PLANNING CONSULTATION RESPONSE

Application No	2026/0265
Proposal	Amendments to existing car park entrance and layout.
Address	23 Queens Road, Barnsley, S71 1AN
Date of Consultation Reply	16 th April 2026
Consultee	Highways DC

Drawing title:
Proposed Site Plan

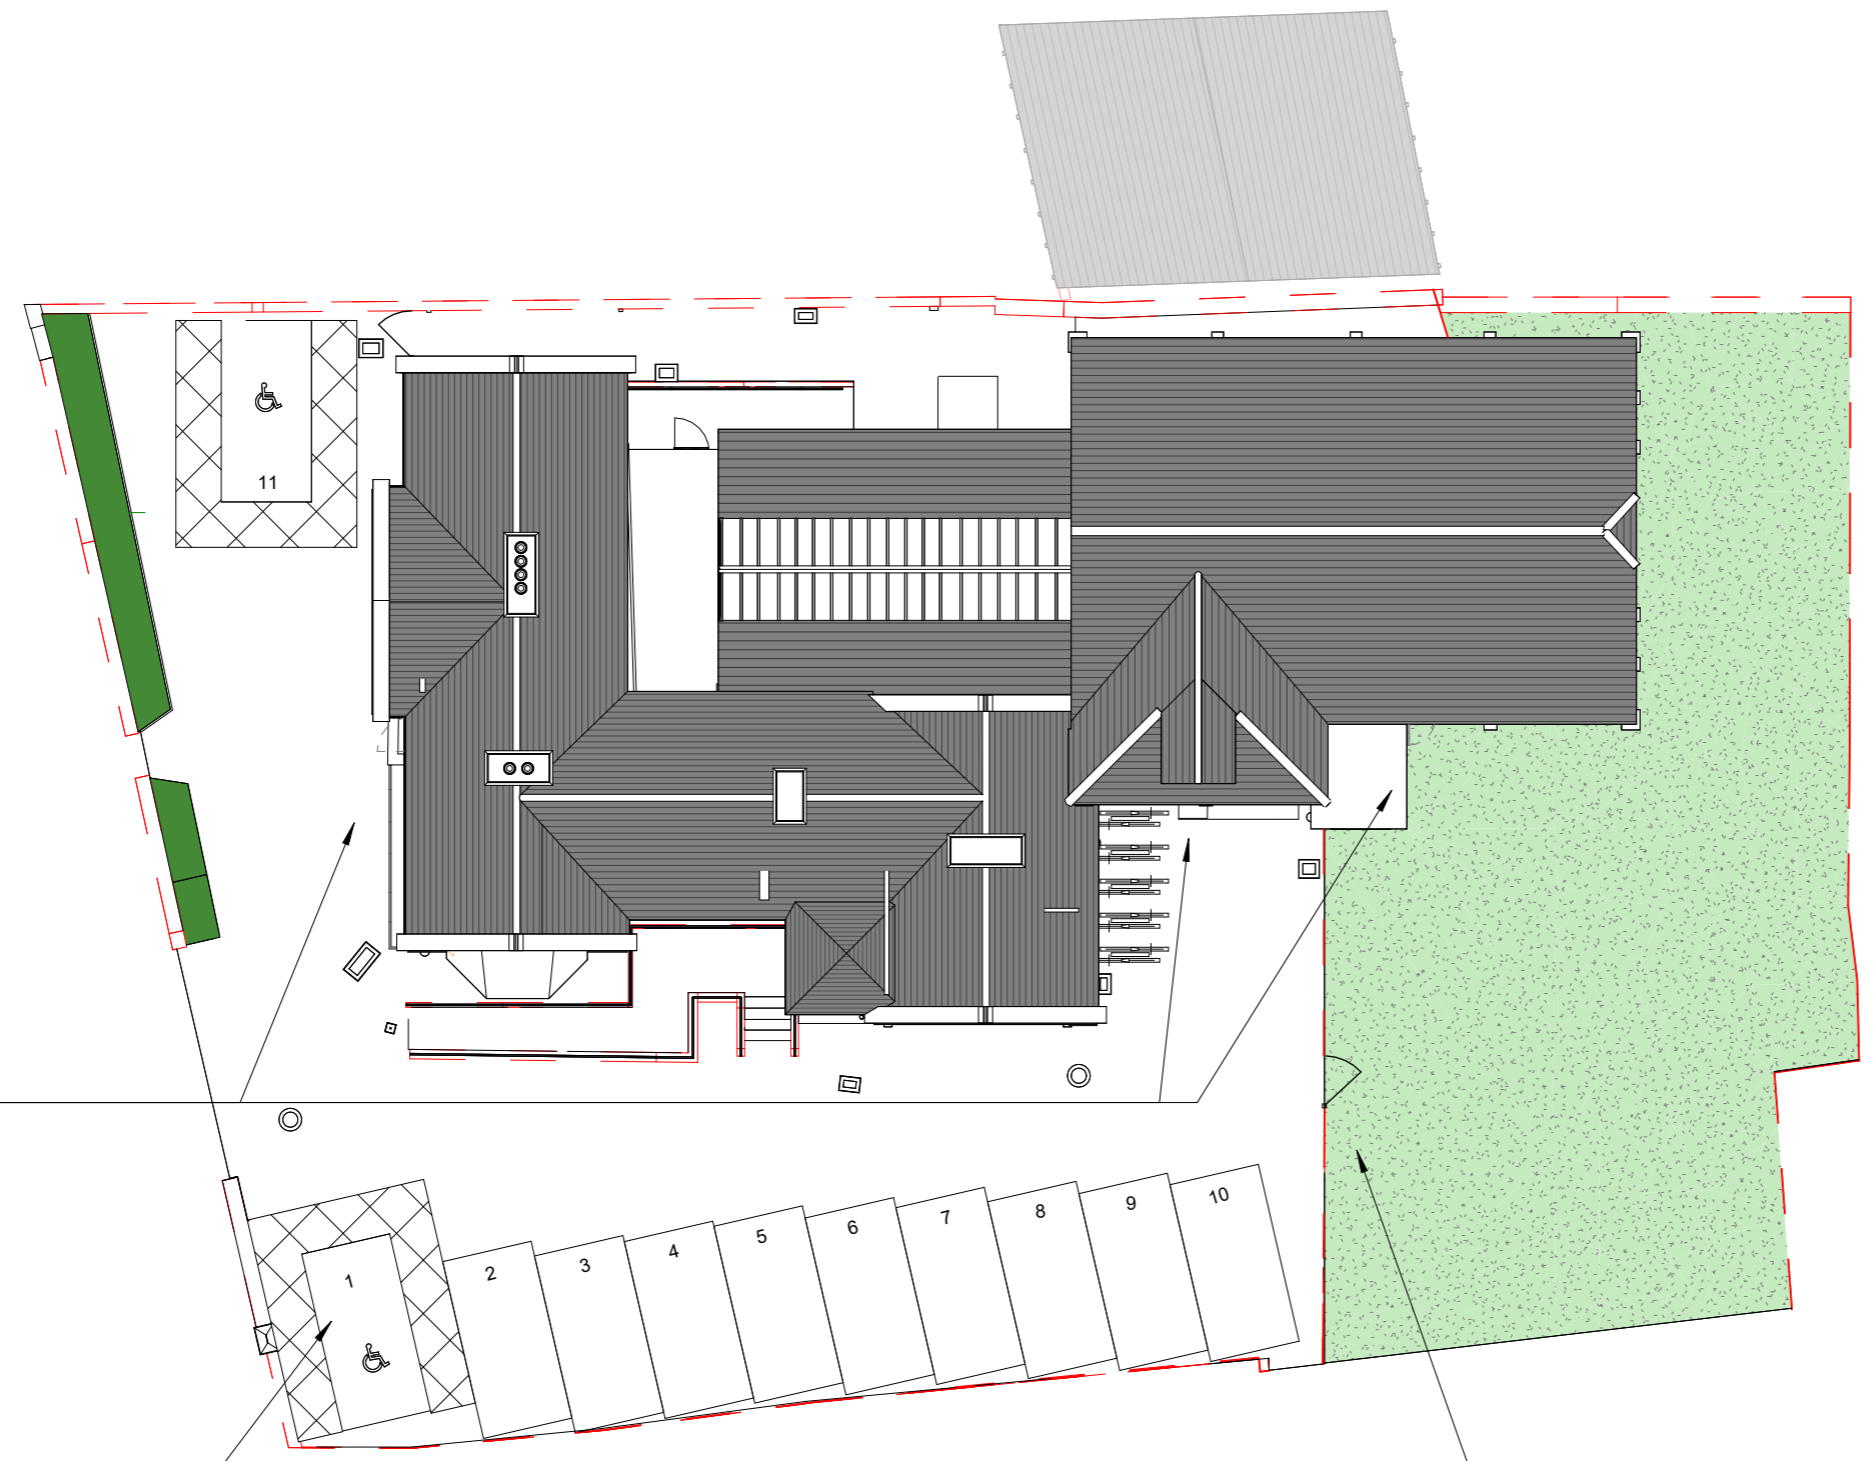
The proposed amendments to the car park layout result in the overall loss of two parking spaces. Although some elements of the layout remain substandard (size of parking spaces and manoeuvring room for example), it must be borne in mind that the proposals are for minor amendments rather than a full redesign of the parking area and that the car park could continue to operate in perpetuity as it currently exists.

As such, it is proposed for the Office use building to have reduced off-street parking provision for 11 vehicles rather than the existing 13. The building has a floor area of approximately 700m² which equates to a parking requirement for 23 spaces (1 space per 30m² of floor area for office use); the site has therefore been operating for many years with a significant under-provision in off-street parking. This has no doubt been aided by the very sustainable location of the site on the edge of Barnsley town centre and the site being within a 320m walking distance of the Interchange.

Given that the site has operated without issue for a significant length of time and that the site is in a very sustainable location, it is considered that the small reduction in off-street parking provision would not adversely impact upon the highway and the proposals are therefore acceptable from a highways development control perspective. Should you be minded to grant permission, I would be grateful if you could include the conditions listed below:

The access, parking and manoeuvring facilities, indicated on the submitted plan, shall be surfaced in a solid bound material (i.e. not loose chippings) and made available for the access, parking and manoeuvring of motor vehicles, and shall be retained for said purposes at all times. Adequate measures shall be so designed into the proposed vehicular areas to avoid the discharge of surface water from the site on to the highway.

Sight lines, having minimum dimensions of 2.4m x site frontage, shall be provided at the site access junction with Queens Road, such that there is no obstruction to visibility at a height

exceeding 0.9m above the nearside edge of the adjacent highway. Nothing shall be erected, retained, planted and/or allowed to grow at or above a height of 0.9m which would obstruct the sight lines and they shall be maintained free of obstruction at all times thereafter for the lifetime of the development.

The parking facility hereby permitted shall not be brought into use until pedestrian visibility splays of 2m x 2m to the back edge of the footway have been provided at the proposed access. Nothing shall be erected, retained, planted and/or allowed to grow at or above a height of 0.6m to the rear of the footway which would obstruct the visibility splays. The visibility splays shall be maintained free of obstruction at all times thereafter for the lifetime of the development.
